Hurst Road Association
Green Leys, Hurst Road, East Preston, BN16 3AP

Objection to: **R/64/17/PL**
St Mary's Close, Hurst Road, Rustington, BN16 3AP

As the Chair of the Hurst Road Association I am writing on behalf of the residents to ask that Arun District Council refuse this planning application from MJH Homes.

Drg No: 151117_SS-01 Rev: D

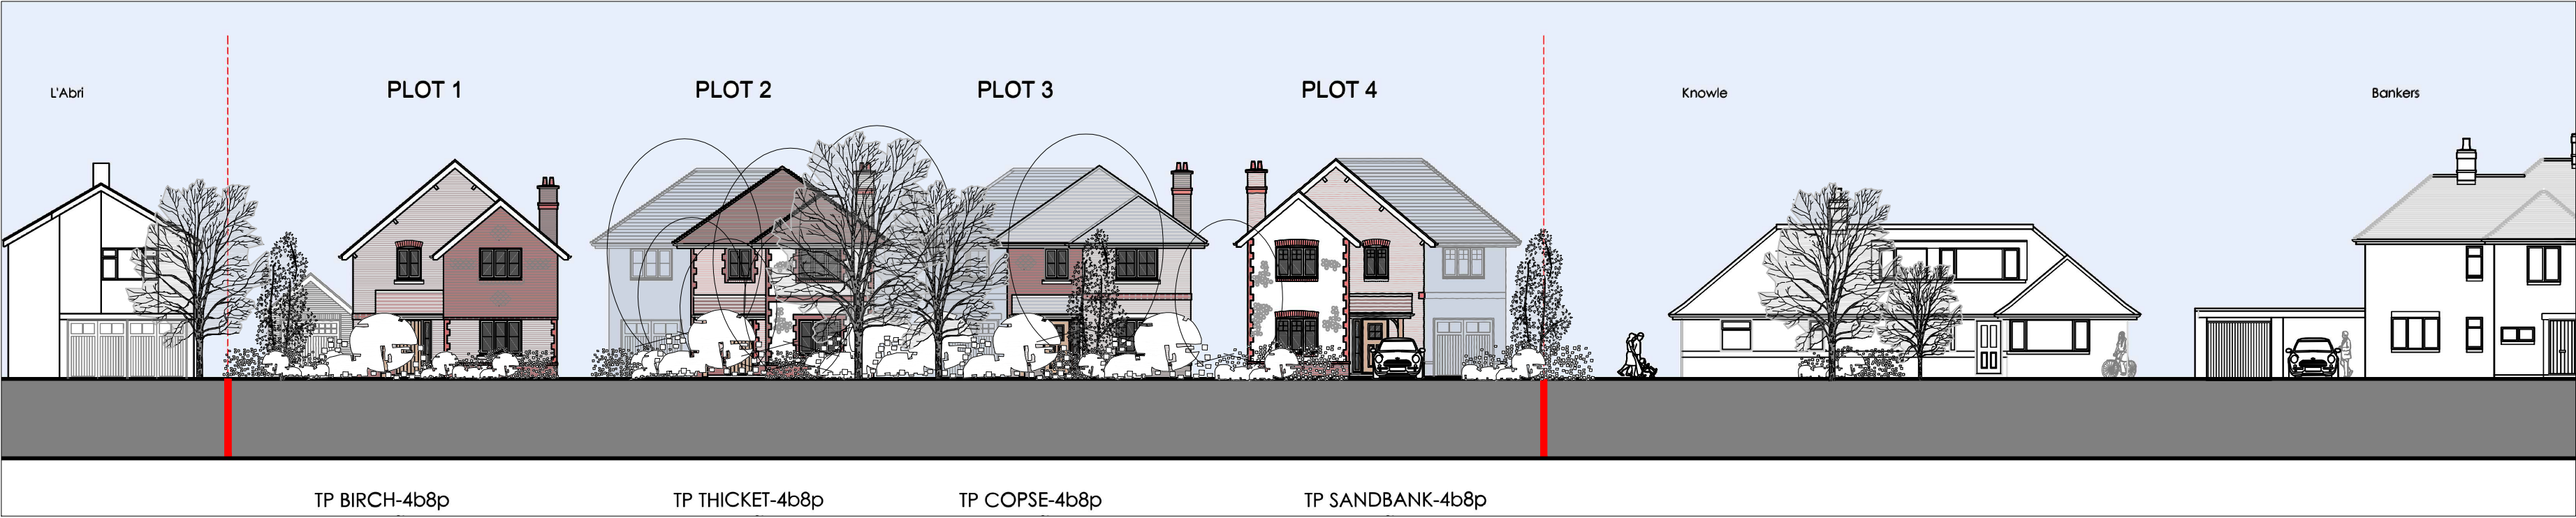
The density of the proposal will be out of character with the rest of the road and will seriously affect the street scene in the eastern part of the road. Although there

would be superficial differences in terms of cladding it still looks very much like two different building styles which are mirrored to make up the development. The Local Precedent Plan (151117 LP-02) clearly shows the distinctiveness of each of the properties in Hurst Road which gives the road its character and we feel this development would detract from this.
